DEVELOPMENT REVIEW BOARD
TRANSPORTATION DEVELOPMENT

DRB Project Number: 1002739
Anderson Heights

SUBJECT: Amended Preliminary Plat, Amended Site Plan for Subdivision, Sidewalk Deferral

Project: Heritage Trails
AKA - Anderson Heights Unit 4A Agenda Item No: 12

TITLE: **HERITAGE TRAILS SUBDIVISION**
OVERALL GRADING & DRAINAGE PLAN

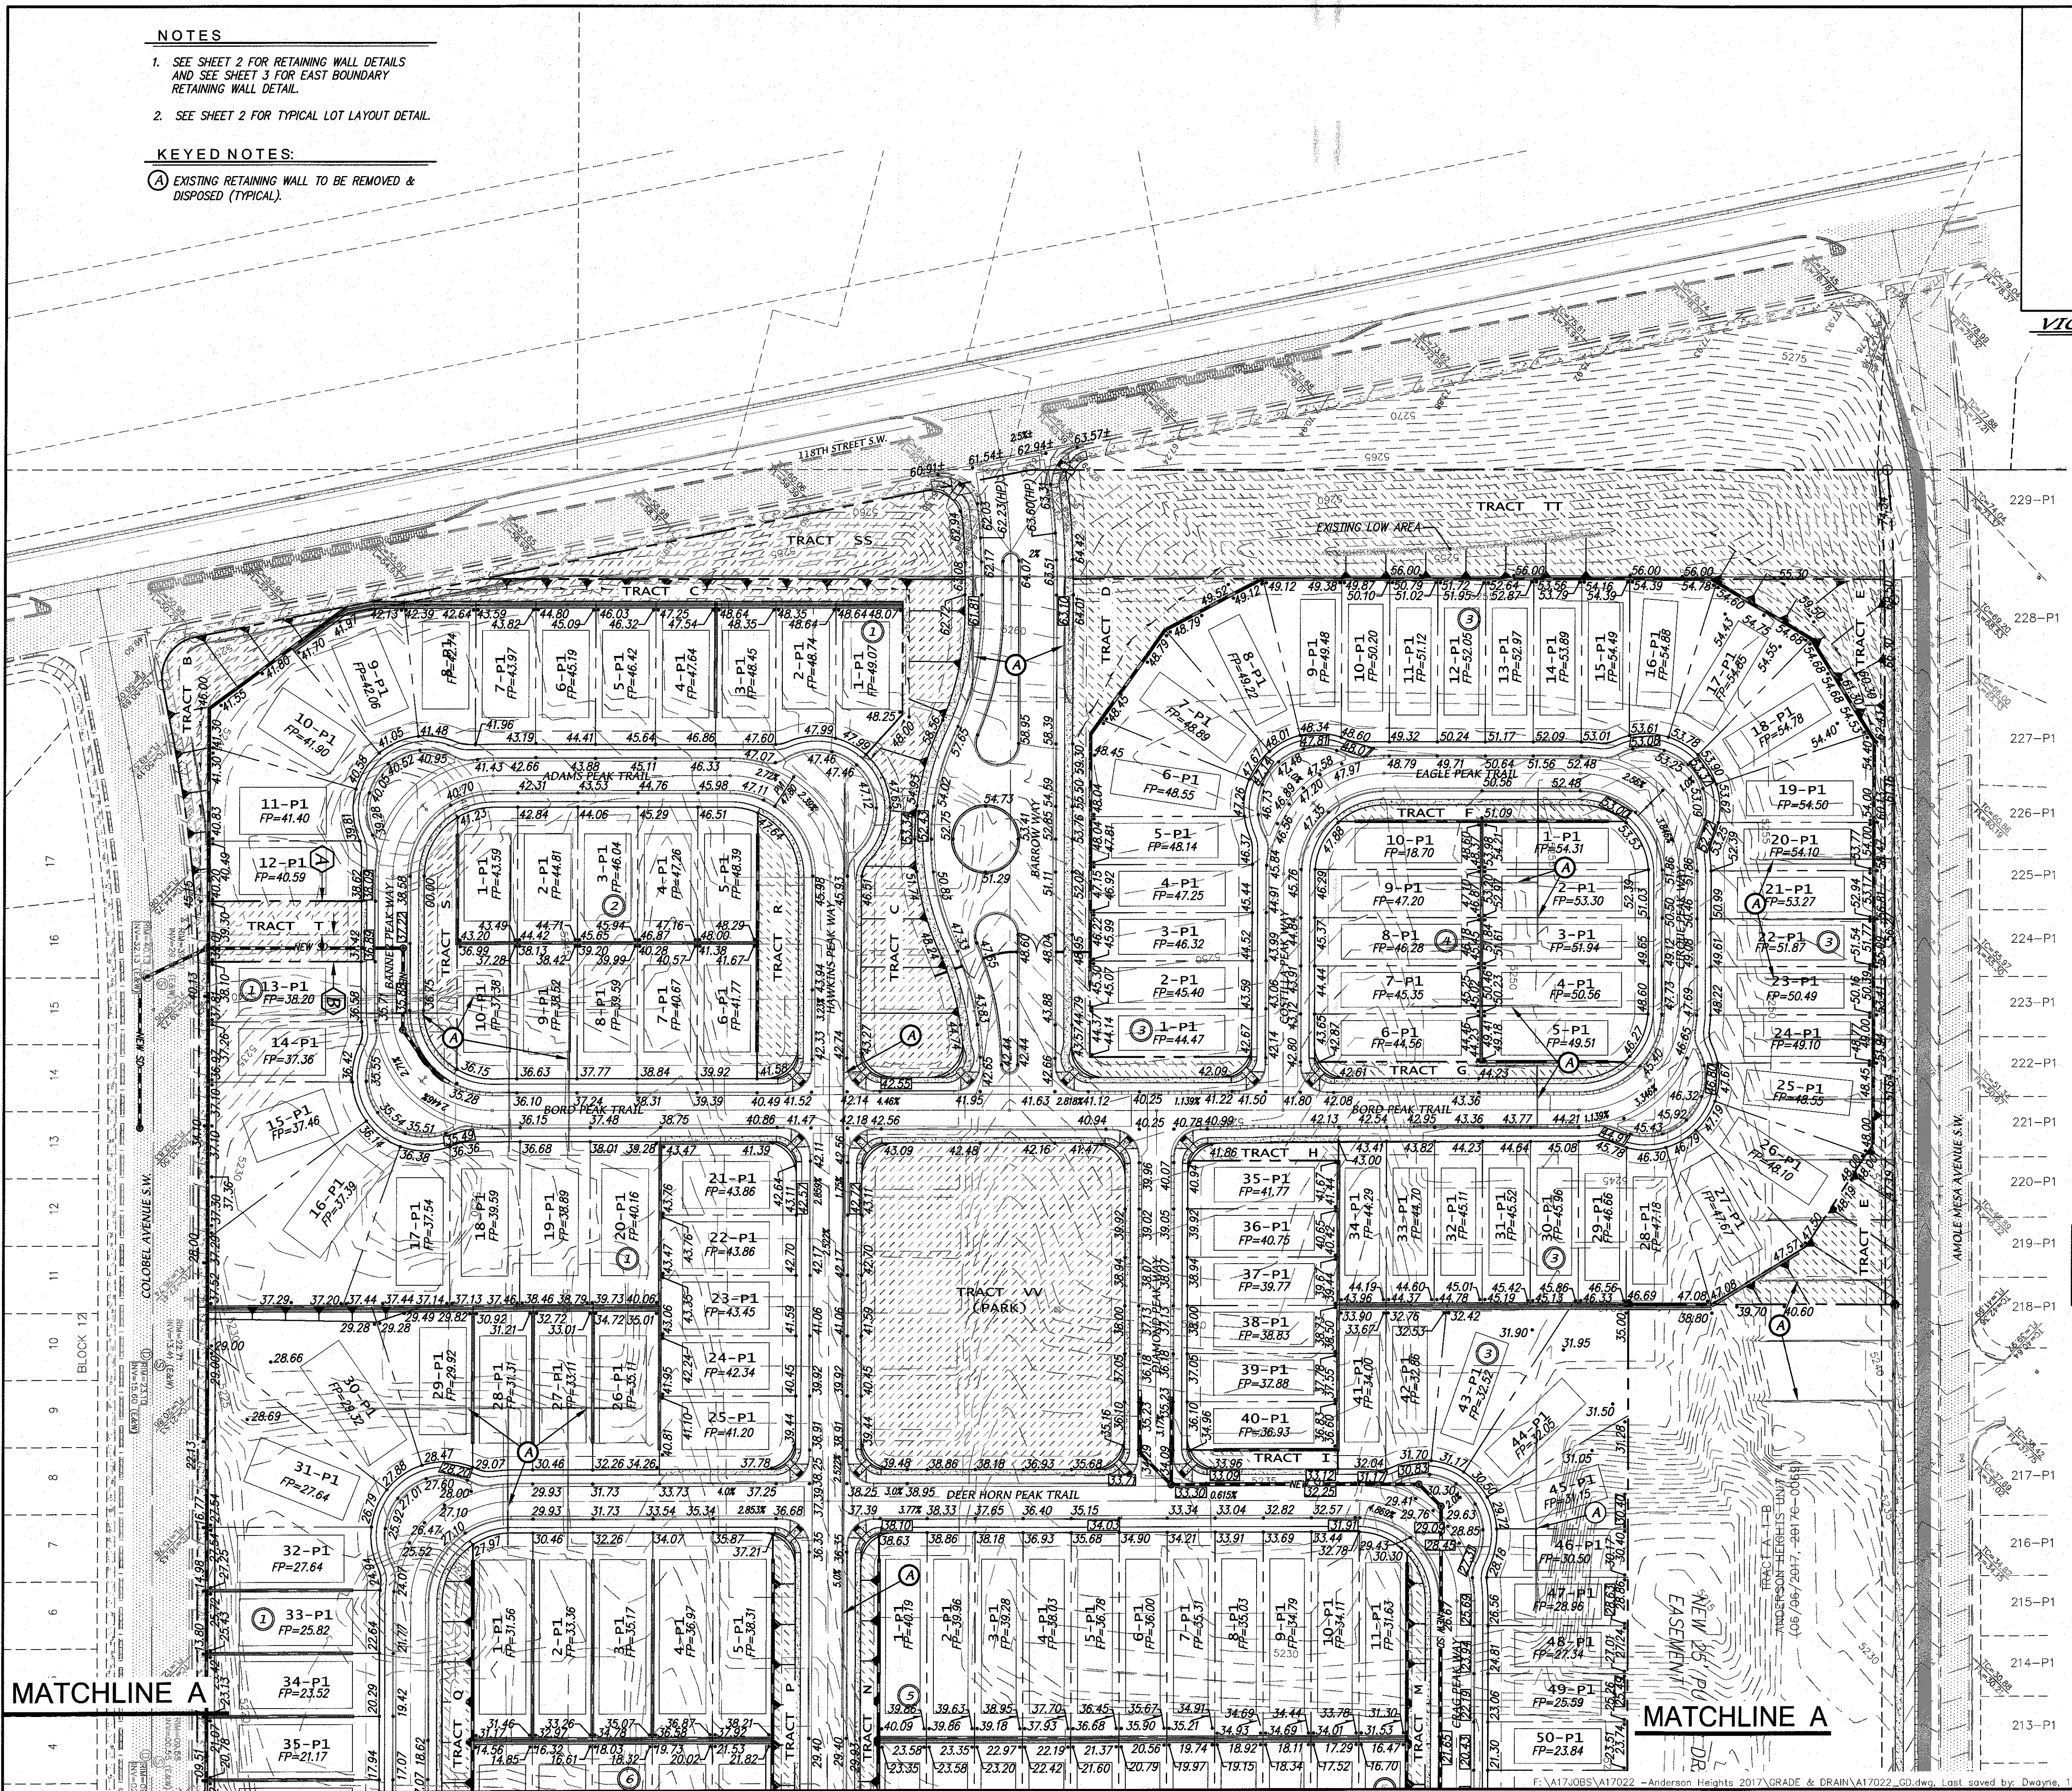
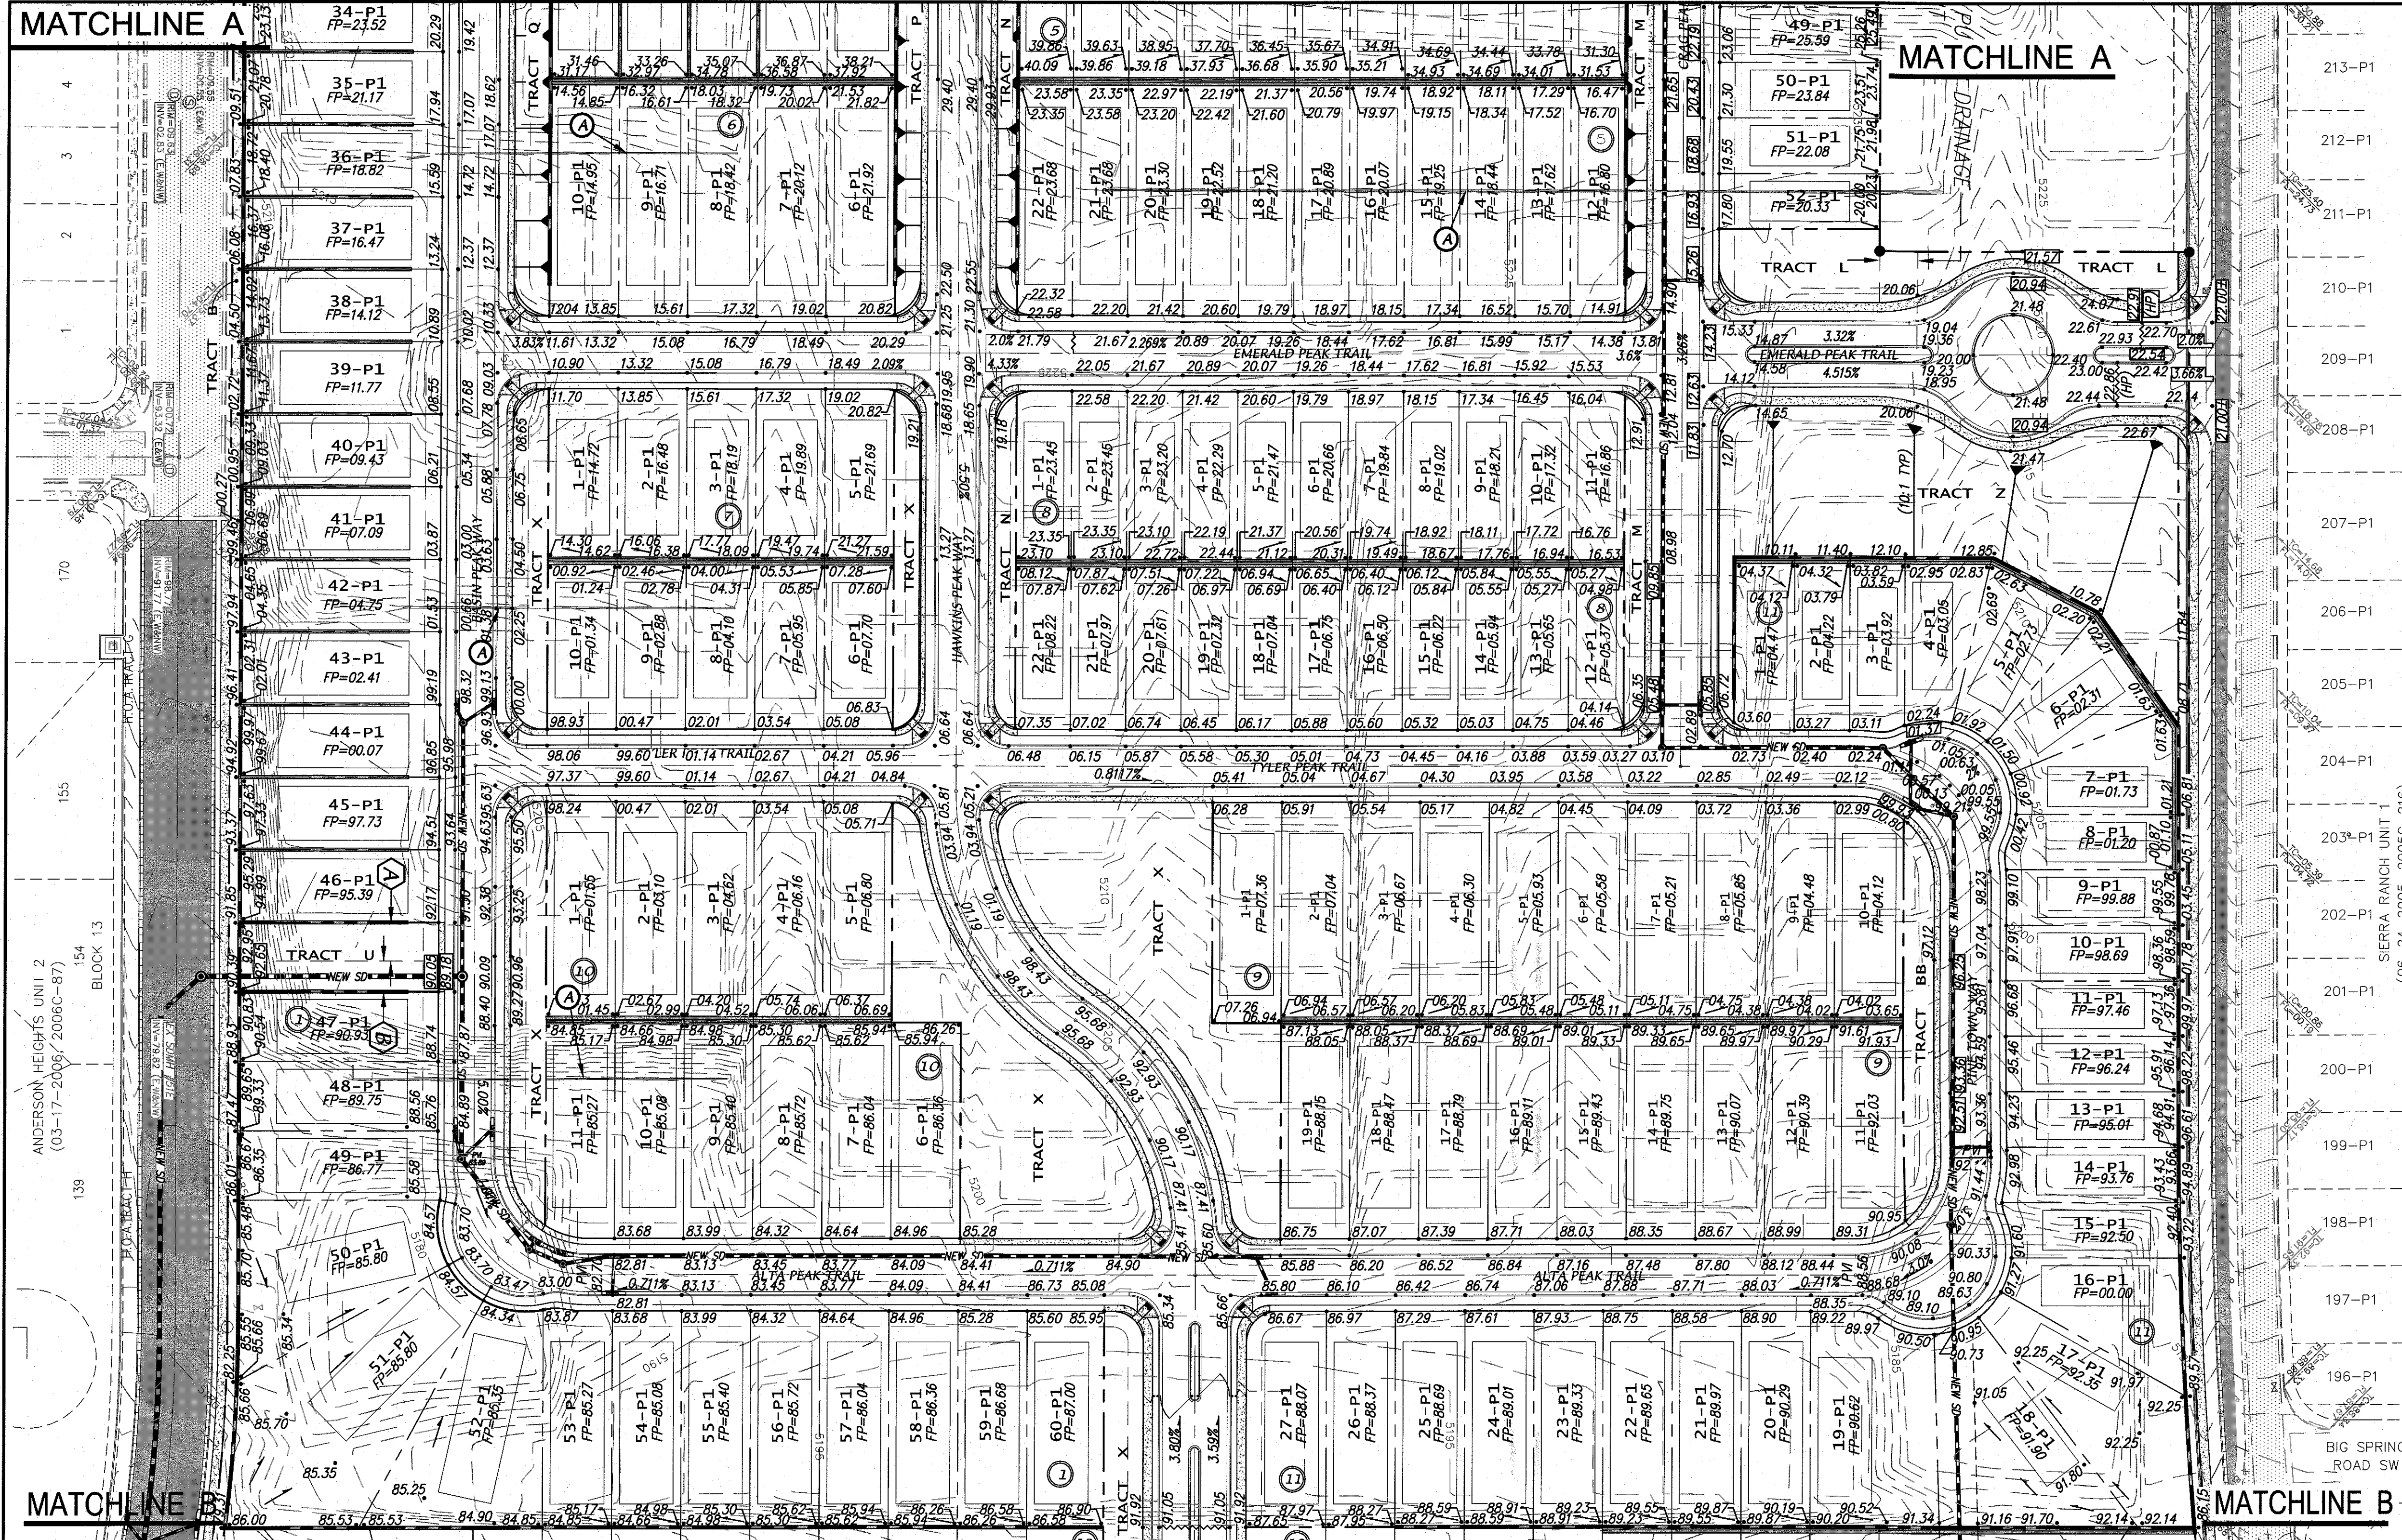
- An approved Drainage Report and Grading and Drainage plan is required.
- A central First Flush Pond (or fee in lieu) will be required.
- Add units 1-3 to the title of the infrastructure list.
